# **01** LETTER OF SUMMARY OF RESPONSES TO COMMENTS

**Re: Summary of Responses to Administrative Amendment Application Comments  
Bernalillo County Regional Outdoor Sports Complex located at 5601 University Blvd SE  
Project #SI-2019-00315**

B4 BICYCLE RACKS
NTS

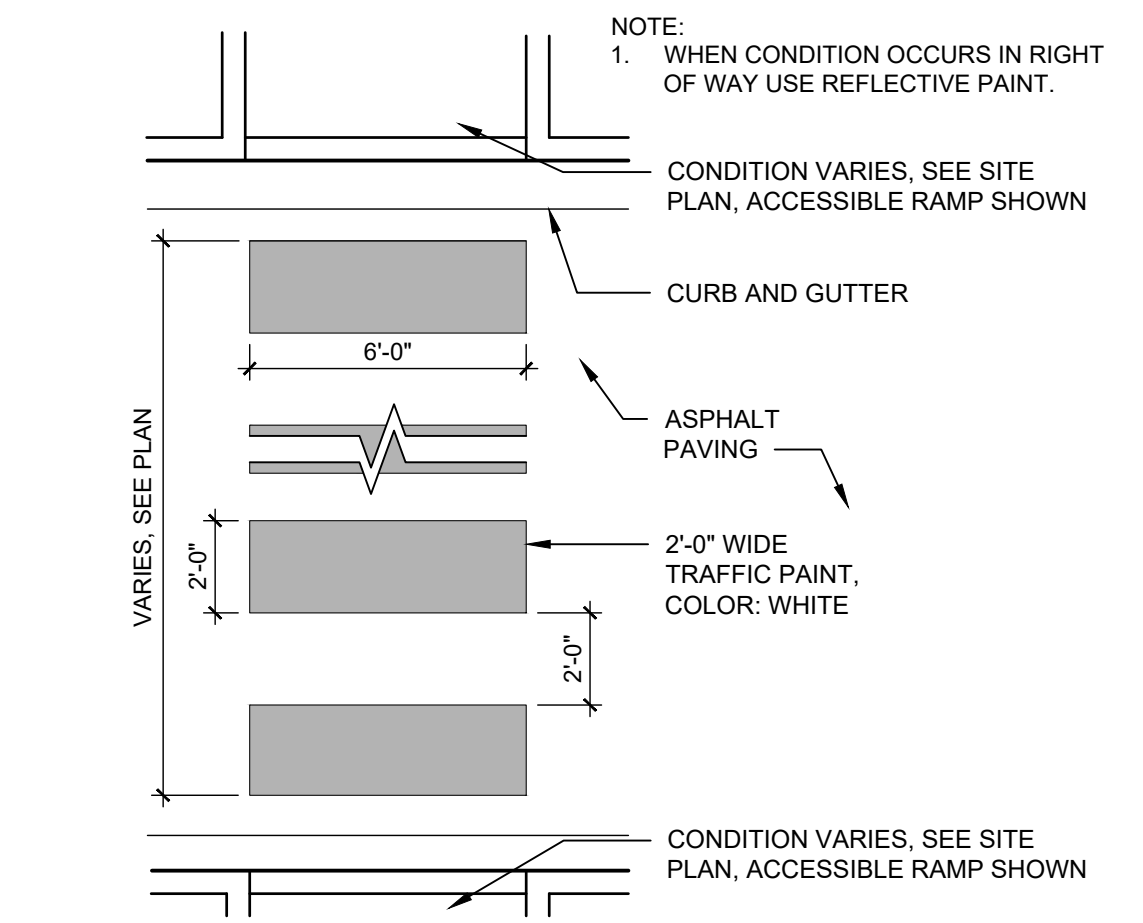
**Comment 5: Provide details for curb, pedestrian ways, curb ramps signage, crosswalks, and bike racks.**

**Comment 10: Provide required motorcycle parking and motorcycle parking signage as well as bicycle parking per the IDO requirements.**

Details for curb, pedestrian ways, curb ramps signage, crosswalks, and bike racks are located on sheets AS101, AS102, AS401, and AS402.

Motorcycle and bicycle parking calculations have been added to the parking calculations on sheet AS102 and are indicated on sheet AS402 in details C4 and B4...
